**Consultation Response from KC,
 Lead Local Flood Authority**
**2020/92067 former, Stile Common Infant & Nursery School, Plane Street, Newsome,
 Huddersfield, HD4 6DF**
Erection of 30 dwellings
**Date Responded: 5
 August 2020**
**Responding Officer:
 Aleksandra Tomczyk**
Responding Ref: 0
Summary
Kirklees Flood Management and Drainage, as the Lead Local Flood Authority (LLFA), OBJECT and require FURTHER INFORMATION is submitted on the following aspects:

Job No.
1375/02

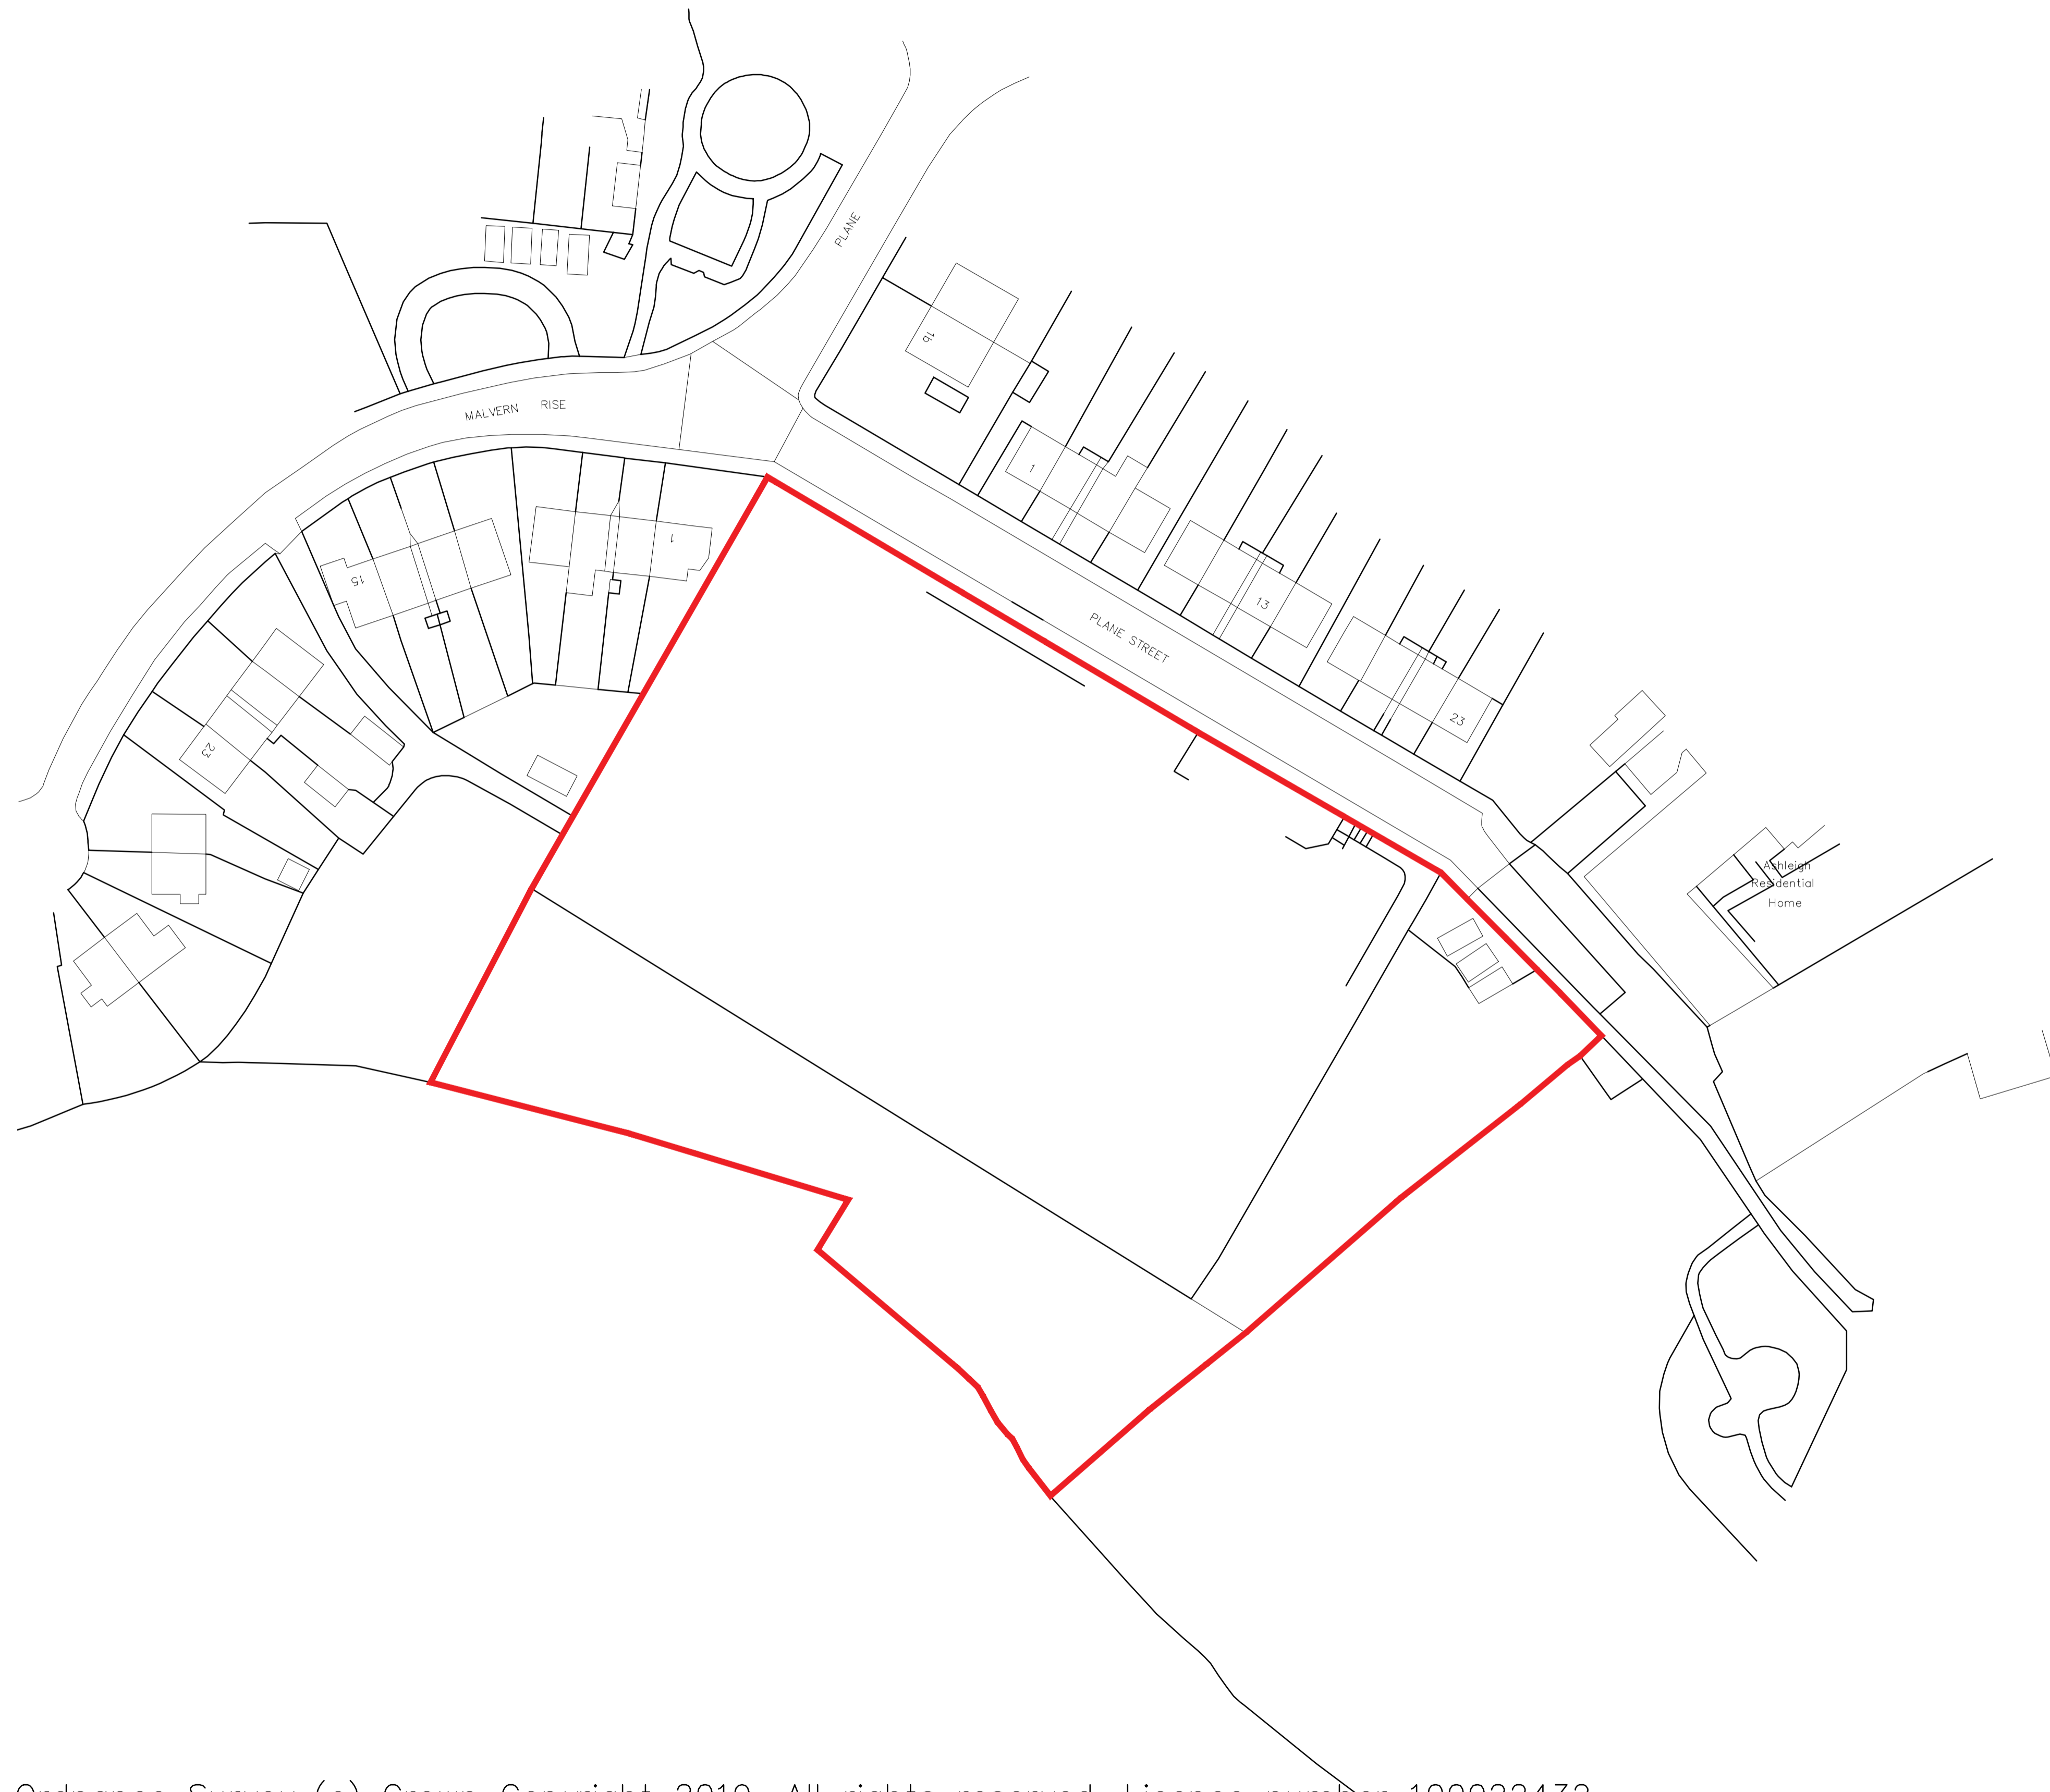
- The applicant proposes to discharge surface water at 5l/s. Discharge rate from all sites should be at pre-development greenfield equivalent run off rates. This rate should be calculated for only the impermeable/positively drained areas, not for the entire site. For brownfield sites, if justification can be made for a higher rate, it may be considered. However, the development must provide a minimum 30% improved situation on existing discharge rate for all events and provide evidence as to why the proposed discharge is the lowest feasible. The applicant must provide relevant calculations for the proposed discharge rate for review and approval by Kirklees LLFA.

- The LLFA have **no objection in principle** to the proposed discharge point – an existing culvert along Newsome Road, however, means of connection need to be confirmed and the system should be surveyed to ensure it is in a suitable condition to receive formalised flows.

- The applicant should confirm the proposed sizing of the attenuation tank – the drawing submitted only provides the area (111m²) but not the depth, and therefore volume of the structure.

- It appears that currently there is a retaining wall in the area where the attenuation tank is proposed to be located. The applicant should confirm whether this structure is to be retained on site. Retaining structures close to attenuation tanks must be carefully considered as some structures may generate lateral loading to soils when full.
